From: Maddie Medric <maddie@southern-energy.com>
Sent: Tuesday, June 24, 2025 4:13 PM
To: Central Permitting Mailbox
Subject: Re: Permitting Process for Roof Mounted Solar

Do you have an update on the solar permit for 213 Windswept Way?

Your plans were Disapproved with the following notes:

AHJ:
TOWN OF FUQUAY-VARINA

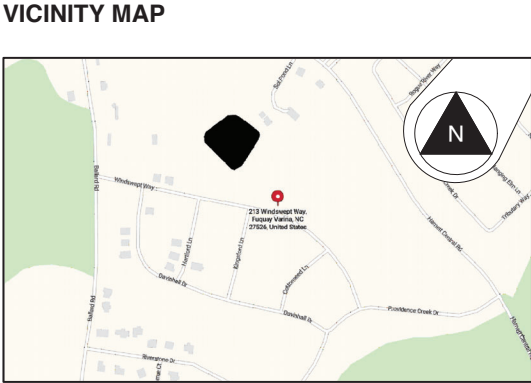
1. AHJ is Harnett County, Not Town Of Fuquay.
2. Need information sheets on all equipment to be installed.
